## Planning Application – Anglian Water Response

Site: Land off Monks House Lane Spalding PE11  
3LH

Proposal: Hybrid application: Full planning application for the erection of 160 dwellings and associated infrastructure, demolition of existing buildings and outline planning application for the erection of up to 274 dwellings.

Planning H16-0584-25  
application:

DRAINAGE STRATEGY
GENERAL ARRANGEMENT
SHEET 2 OF 2

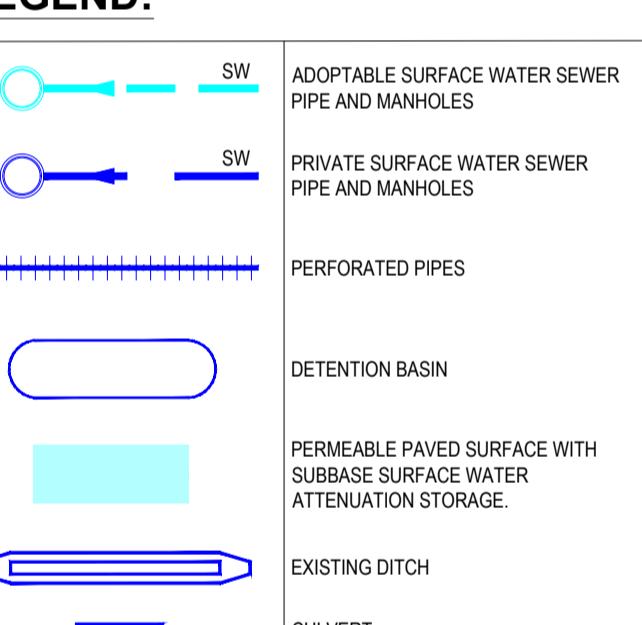
The applicant has indicated on their Flood Risk and Sustainable Drainage Strategy Report Rev P01 dated 02-04-2025 and Drainage Strategy General Arrangement Sheet 1 and 2 that their method of surface water drainage is via SuDS with an outfall into a ditch.

If the developer wishes Anglian Water to be the adopting body for all or part of the proposed SuDS scheme the Design and Construction Guidance must be followed. We would recommend the applicant contact us at the earliest opportunity to discuss their SuDS design via a Pre-Design Strategic Assessment (PDSA).
